Our Ref: TR040011

Planning Act 2008 – Section 51

Application by North Somerset District Council for an Order Granting Development Consent for the Portishead Branch Line – MetroWest Phase 1

Advice following issue of decision to accept the application for Examination

Figure N-3: Pre Development, 20year return period event in 2015 ,Tidal

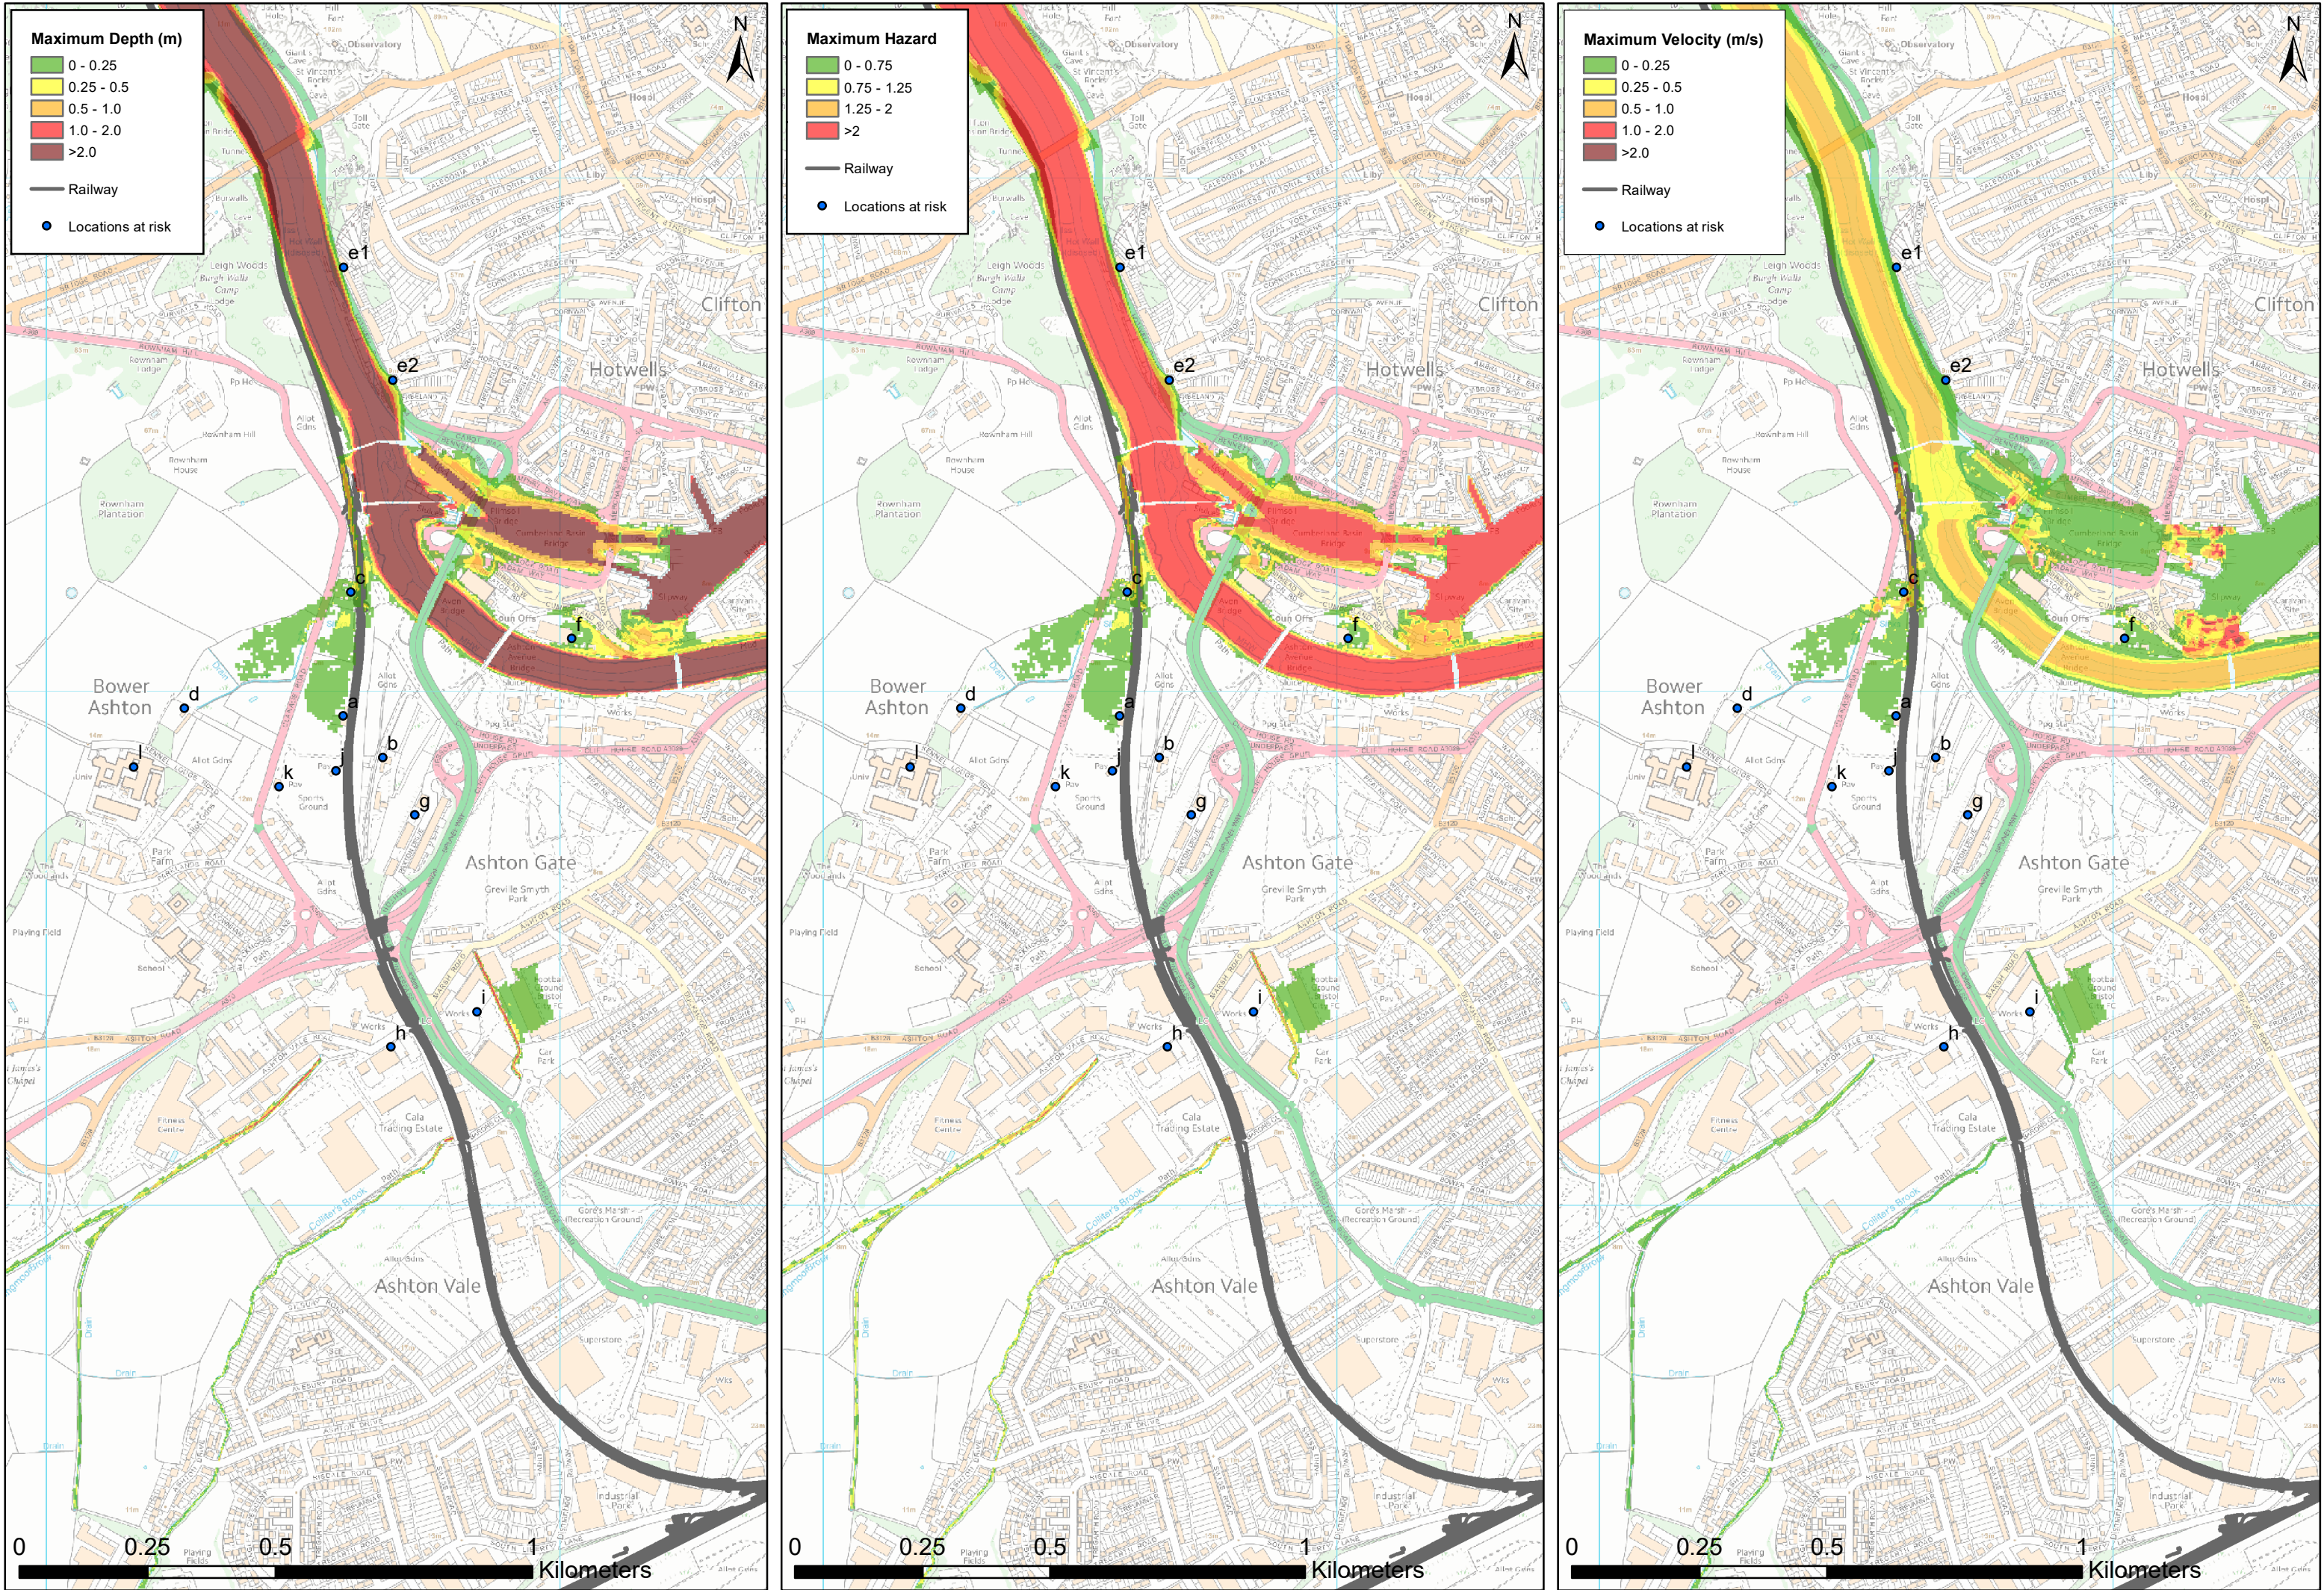
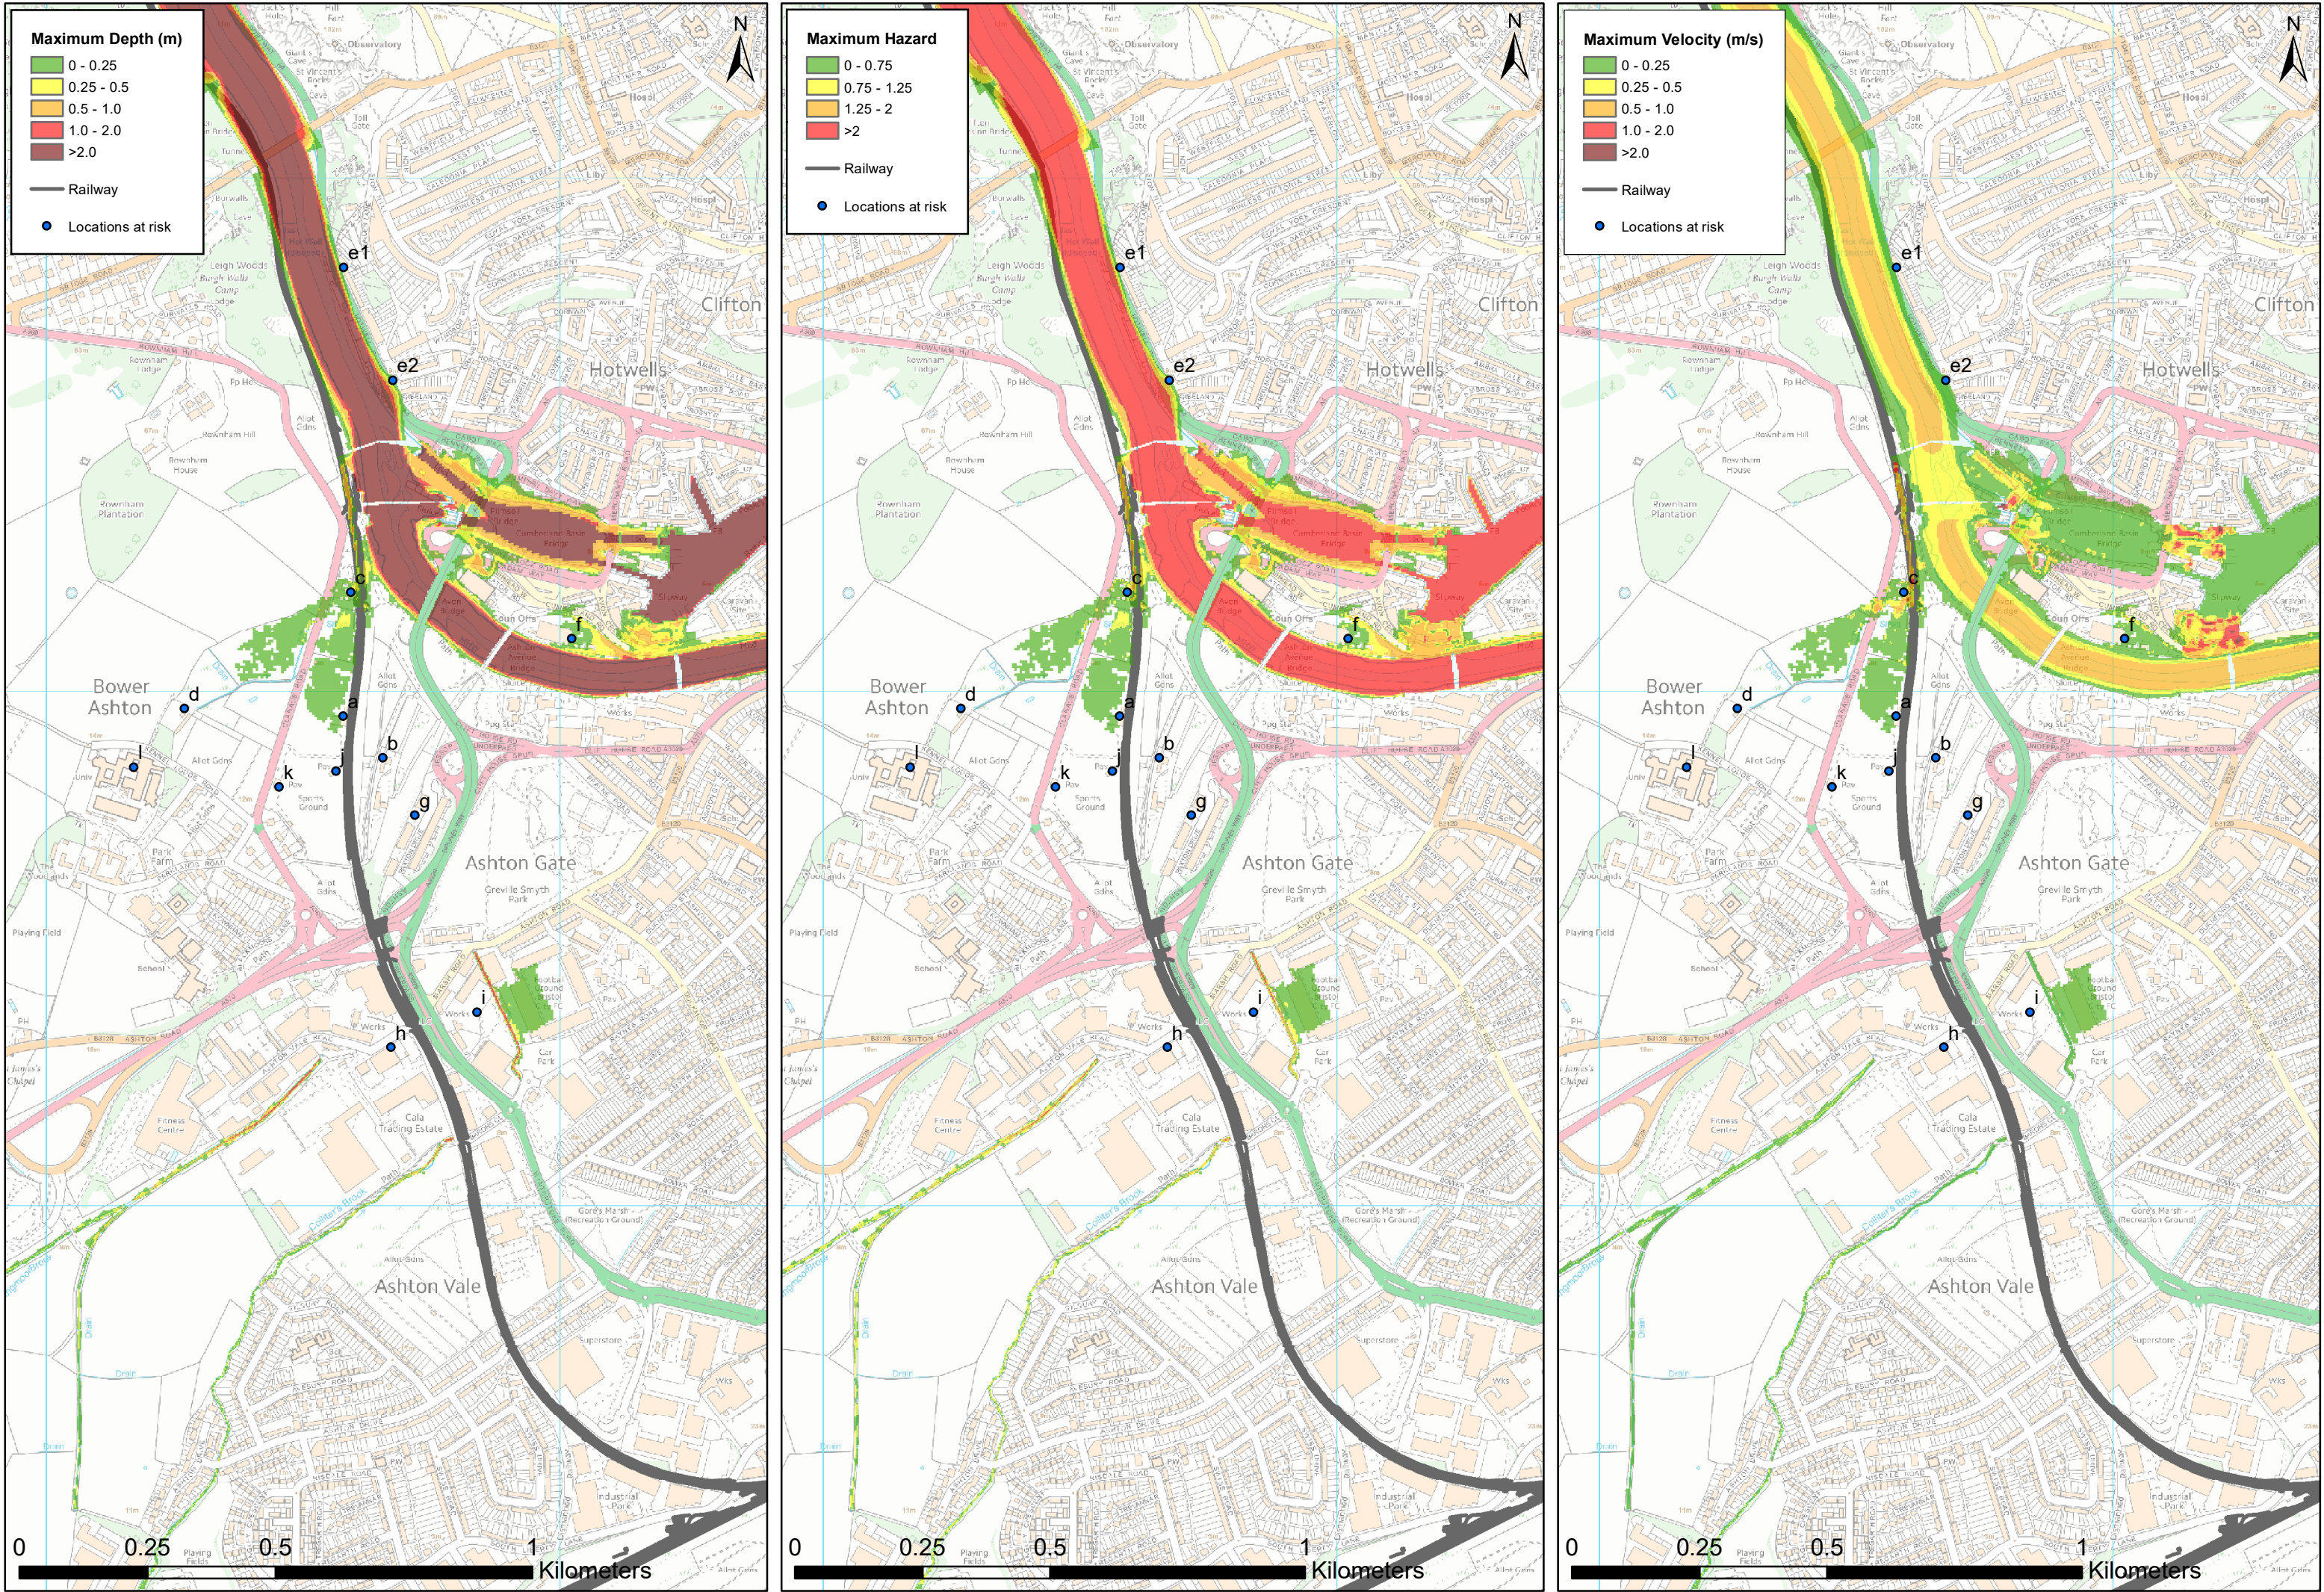
At Bower Ashton - the simulation of impacts from River Avon tidal flooding indicates that this section of the operational NSIP would experience tidal flood events once every 5 to 10 years for the assessment year (taken to be 2015) and more than once a year on average in the future (scenarios 2075 and 2115) (taking into account climate change, including sea level rise, into consideration). In preparation for the examination the Inspectorate seeks to understand the extent to which the application of the revised climate change allowances may (or may not) affect the findings in this regard. In particular, whether such detail would result in anticipated flood events at more frequent intervals and at earlier points in the design life of the Proposed Development.
